East Midlands Gateway
Phase 2 (EMG2)

Document DCO 7.6 / MCO 7.6

Examination Issues Tracker

The East Midlands Gateway Phase 2
and Highway Order 202X and The East Midlands Gateway
Rail Freight and Highway (Amendment) Order 202X

number FIGURE 13.10 rev C

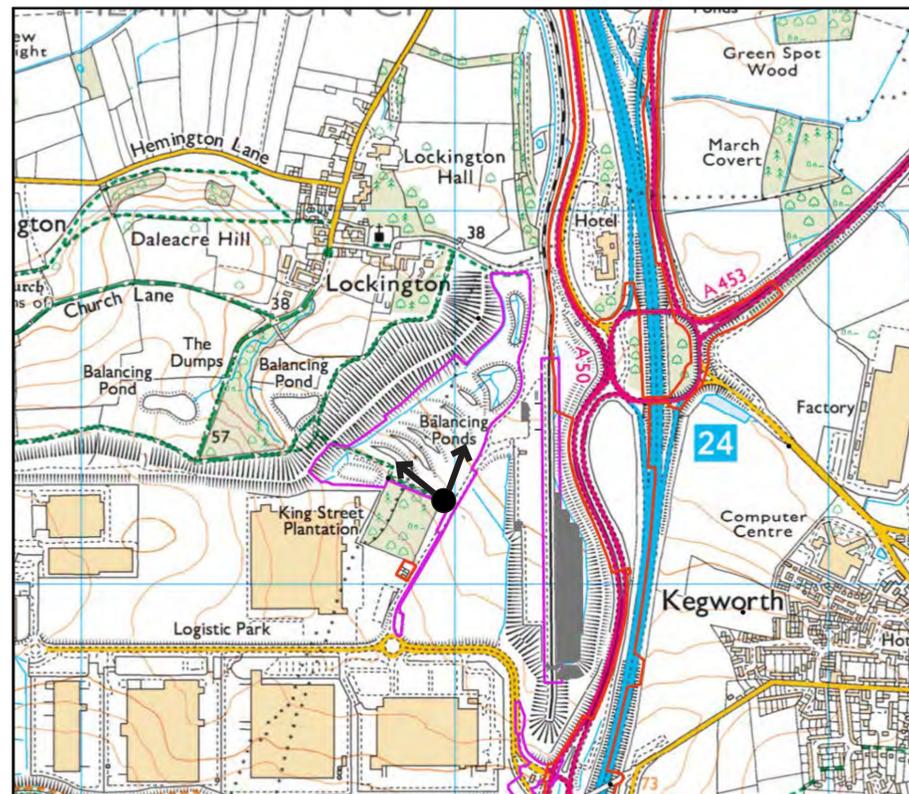
1.	Kegworth Parish Council (KPC)	RR-048M	<u>KPC has not been able to find a visual rendering of how the Visual impact of increased height of cranes and the new warehouse at Plot 16 would impact on the landscape.</u>	<u>MCO 7.2</u> MCO 6.10B / AS-044 , AS-045 , AS-046 , AS-047	The Applicants directed KPC to the visual renderings in figures 13.1 to 13.3 at Appendix 10B to the ES. <u>which provides a photo viewpoint from the edge of Kegworth towards the MCO Scheme.</u>
